From: Laura Gibbons
Sent: 30 May 2019 11:04
To: Planning.Responses
Cc: Amber Willard
Subject: RE: Planning Consultation on: BN/21/19/HH

Engineers Comments Regarding Surface Water Drainage

APPLICATION BN/21/19/HH

Description of Works: Demolition of existing conservatory and single storey garage / utility and replacement with single storey rear and two storey side extensions.

© This drawing is the copyright of Robert Clark Associates Limited It may not be copied or reproduced without their written authority			
Scale	As shown	At original	A3
Drawing Number	1759/D1.3	Revision	-

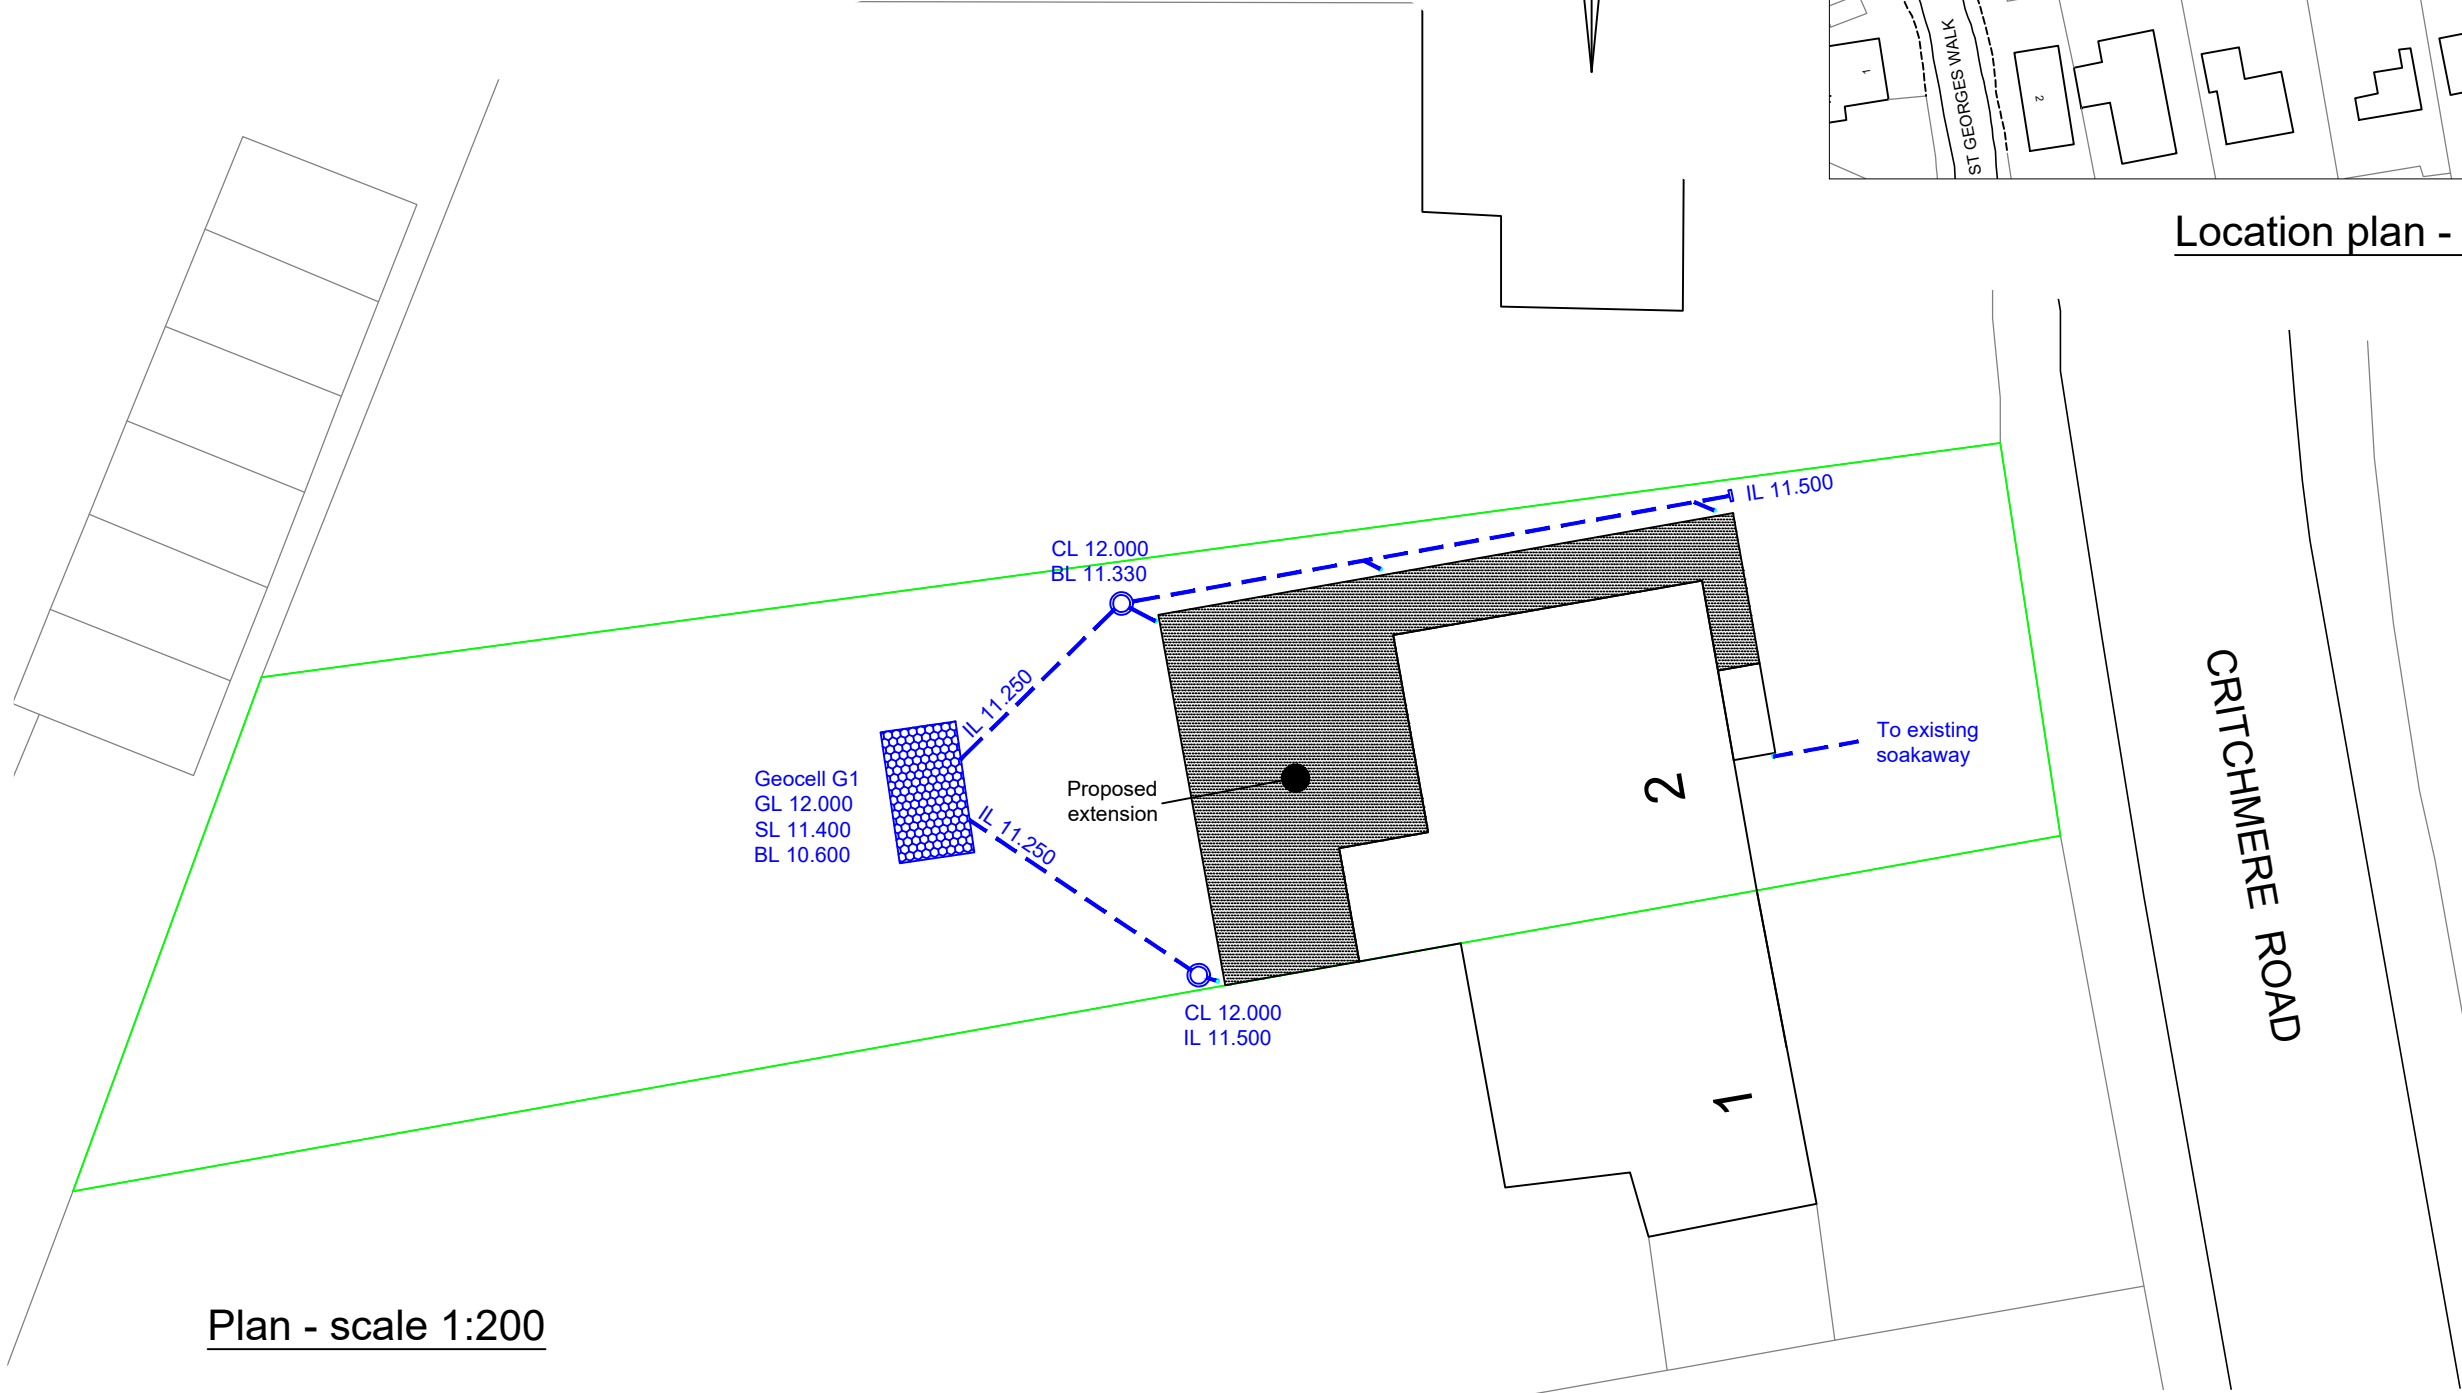
Drainage details have been submitted with this application. These need to be revised to provide a factor of safety of 3 and a climate change allowance of 40%. If this is updated before determination it may be that pre-commencement conditions can be avoided.
